Report of the meeting of the Development Control Post-Committee Site
Inspection Panel held on

REF NO: P/87/11/

LOCATION: 52 East Front Road
Pagham

PROPOSAL: Single storey extensions to residential property - Resubmission following planning application P/47/11.

Project	52 EAST FRONT ROAD, PAGHAM, BOGNOR REGIS WEST SUSSEX PO21 4ST	Drawn	sk	Project	126
For	Mr and Mrs Eysers	Scale	1:100 @ A3		
Title	SOUTH ELEVATION - PROPOSED 2011	Date	25.10.2011	Revision	d
				Drawing No.	P 06

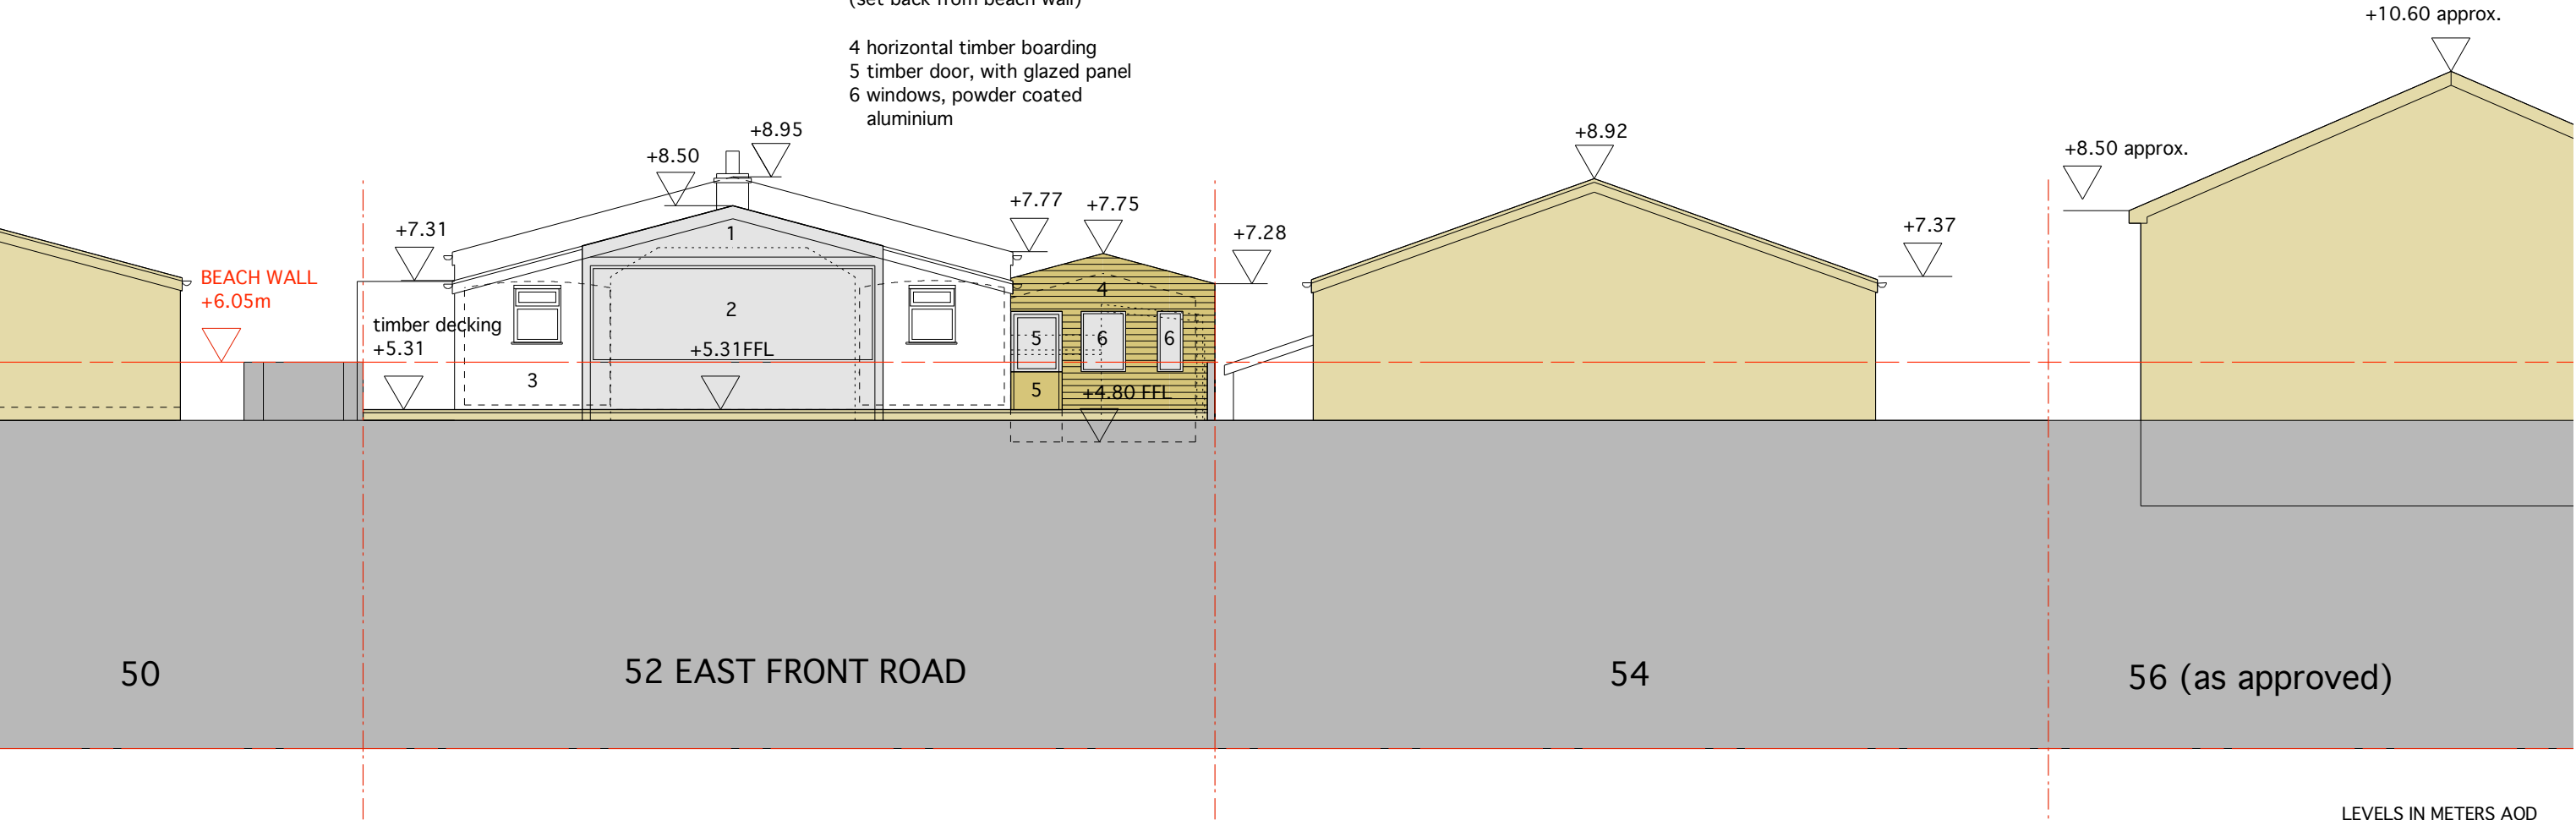
With regard to visual amenity, the proposal is also considered to be acceptable. The ridge height of the proposed extension would match the eaves height of the host dwelling with the majority of the addition set to the side of the dwelling and a narrow flat roof glazed section projecting across a short width of the principle elevation of the dwelling. As such it is considered that the proposed extension would appear visually subservient to the host dwelling. The design and use of materials also reflect the character of the host dwelling ensuring visual integration.

Project	52 EAST FRONT ROAD, PAGHAM, BOGNOR REGIS WEST SUSSEX PO21 4ST	Drawn	sk	Project	126
For	Mr and Mrs Eysers	Scale	1:100 @ A3		
Title	EAST ELEVATION AND SECTION A-A - PROPOSED	Date	25.10.2011	Revision	d
					Drawing No. P 07

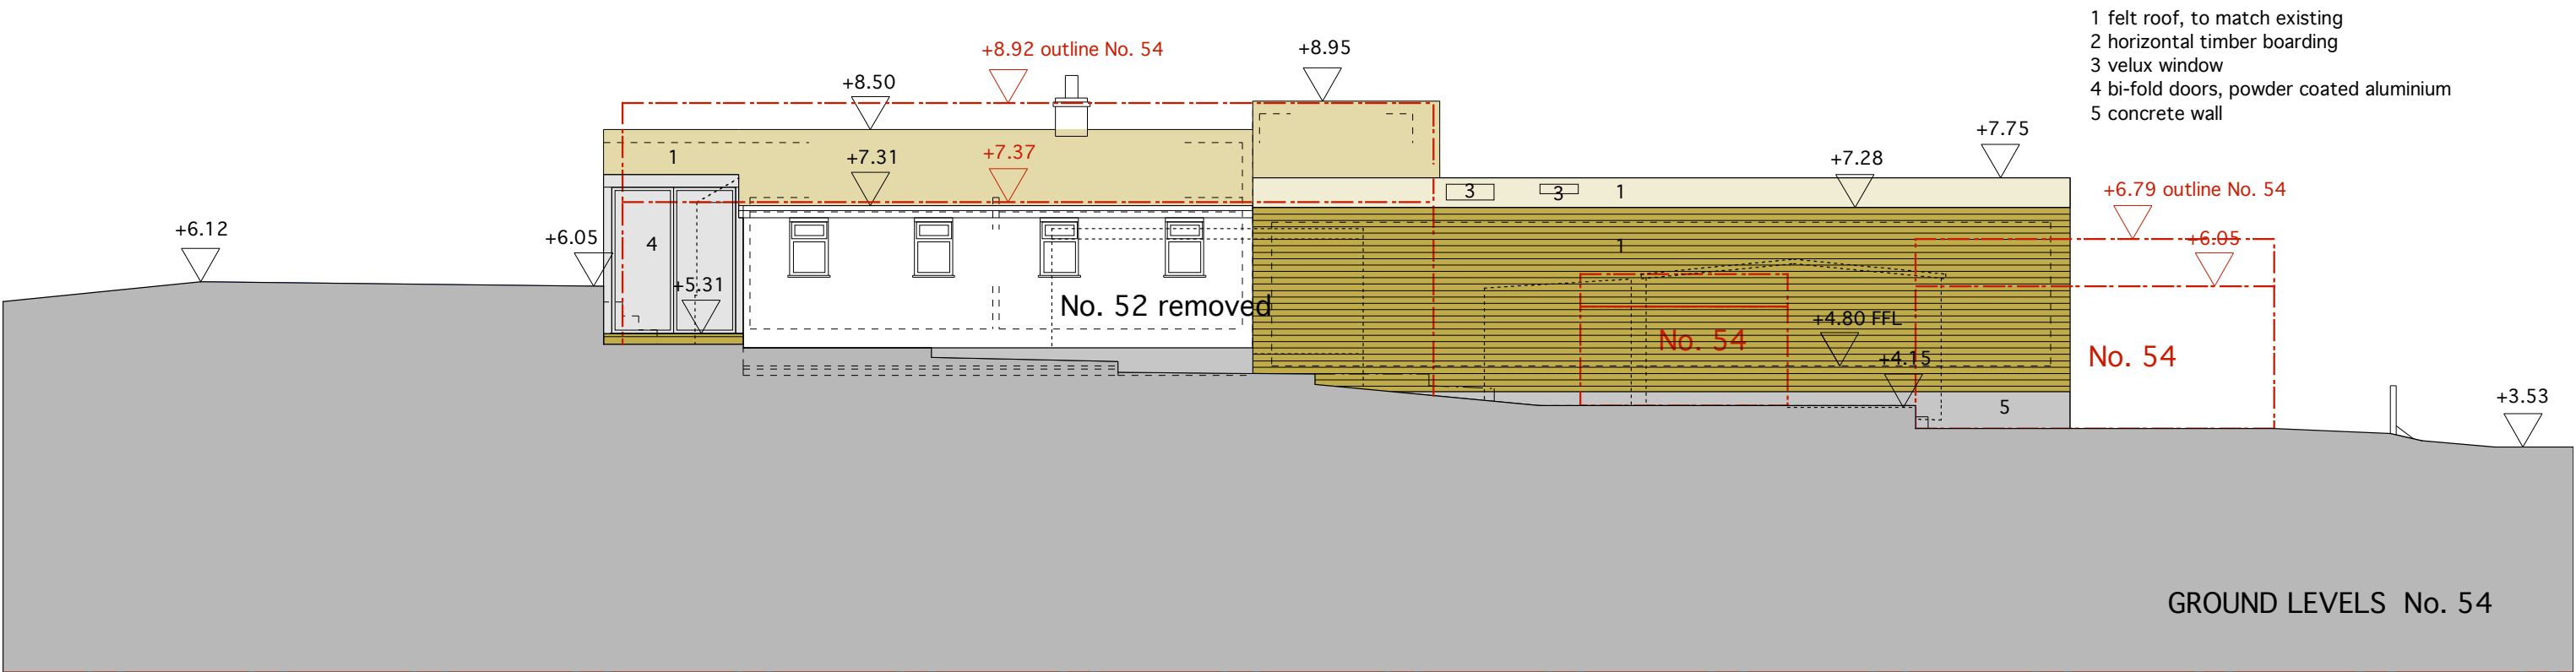
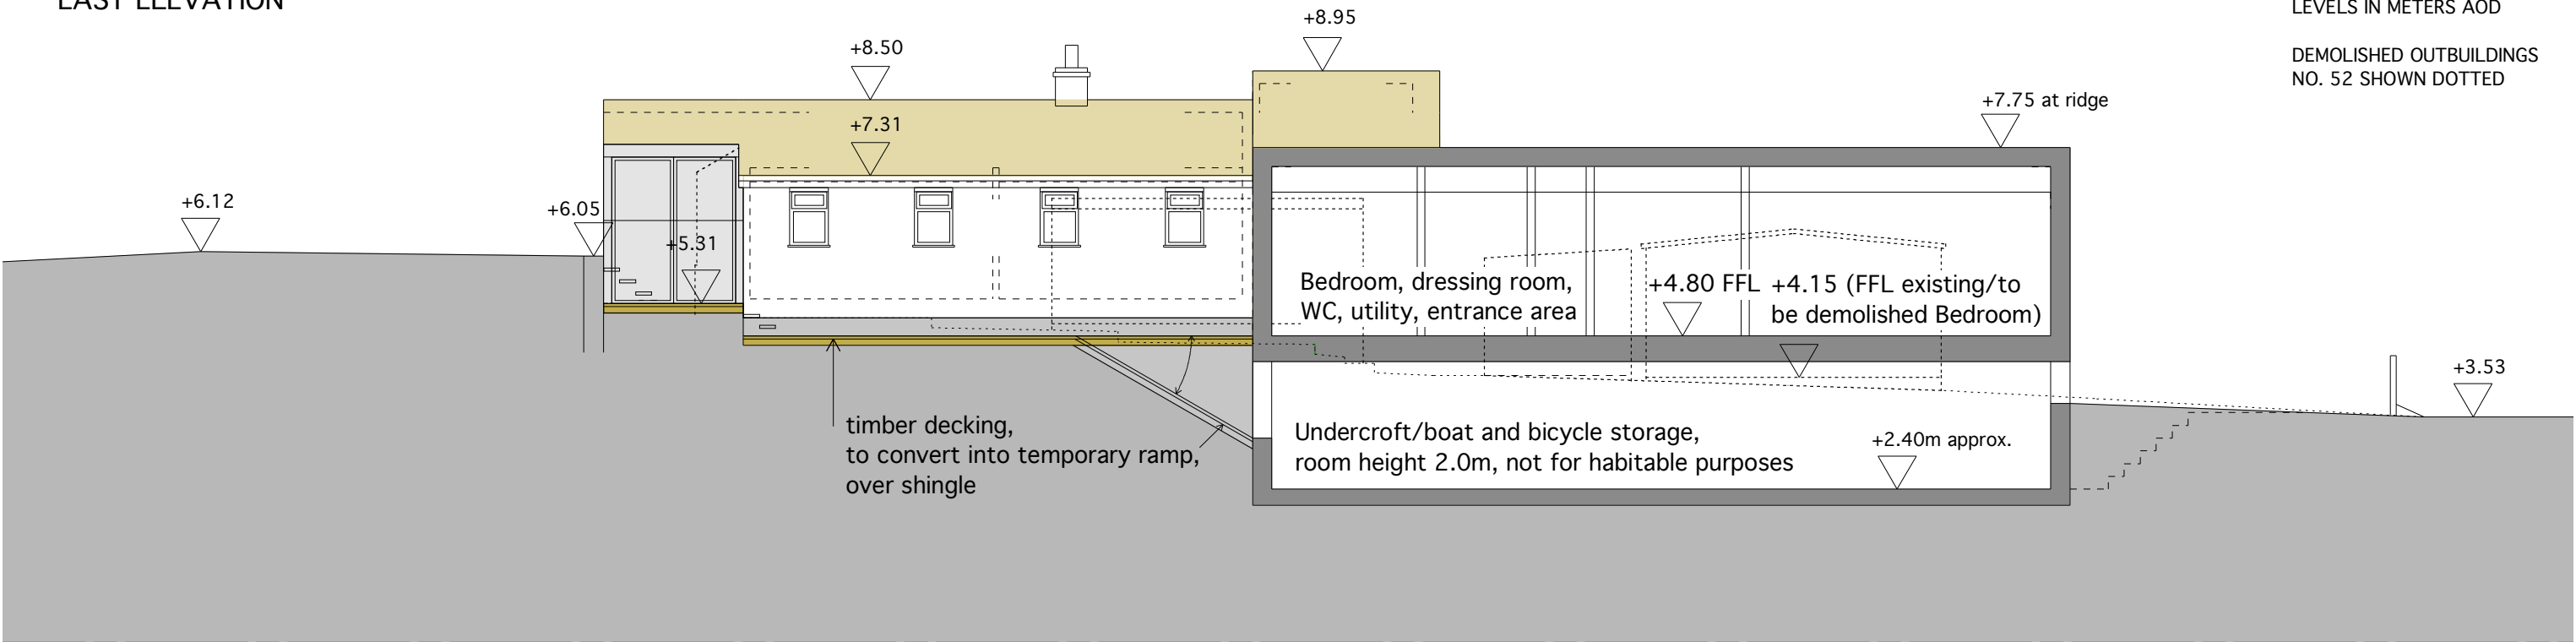
The significant contour rise from East Front Road to the backshore crest from 3.8 AOD to 6.1 AOD dictates that the 'undercroft' will be the subject of very substantial excavation, raising concerns in respect of ground stability and effects upon adjacent buildings. In this respect the Parish Council is aware of concerns of the Residents Association and the major landowner, Pagham Beach Holdings Ltd.

- Boat store must surely be considered a completely unsuitable proposal endangering adjoining properties and result in the basement flooding with any event of over-topping of the sea.

- Extension with roof lights is inappropriate and will undermine the local area plan and village design statement, creating an unwelcome precedent.
- Would create serious overshadowing to the property to the east.

- Floor level of the basement significantly lower, verging on dangerous and removal of large amounts of shingle sub-strata will cause significant local disturbance.

- In the event of the sea over-topping the shingle bank, all drainage will be onto 54 East Front Road which is unacceptable.
- The description of the under-croft is misleading, and will fill with water when there is heavy rain or over topping of the sea. Also concerns that it will be used for extra accommodation to house guests and children.

With regard to residential amenity, it is recognised the side extension would abut a site boundary, and that, because of the provision of a basement store below the extension will be of a greater height than it would be otherwise. This creates a potential for overshadowing onto the neighbouring property to the east.

The application also proposes 3No. roof lights within the eastern roof slope. These are set back from the front section of the extension and given the shallow pitch of the roof, would not appear prominent in the street with only glimpses available of these when approaching from the east of the site. Whilst the site is located within the Pagham Area of Special Character in which development within roof slopes is not encouraged, given their siting and scale and that they serve ground floor accommodation they are considered to be acceptable in this instance.

Whilst the extension does provide a ground floor with basement below, the extension does remain single storey in height and appearance, with the roof angled away from the north-east boundary. The submitted plans also identify that the addition now proposed is reduced in height by 400mm and reduced in depth by approximately 1.1m to that of the scheme approved under P/72/11.

As such given this previous approval and the overall reduction to the height and depth of the addition, the proposal will have a lesser impact upon the neighbouring property to that already deemed acceptable. It is therefore considered that the extension would not detract from the amenity of the neighbouring site by way of an overbearing affect or loss of light.

- 4 The basement/under-croft area hereby permitted shall only be used for storage in connection with No.52 East Front Road and for no other purpose whatsoever.

- 5 Finished floor levels of the dwellinghouse and extensions hereby permitted shall be set at those levels as annotated on the plans hereby approved and as recommended by the applicants Flood Risk Assessment, and those buildings shall be constructed and maintained as such thereafter, and shall not be altered without the prior written consent of the Local Planning Authority
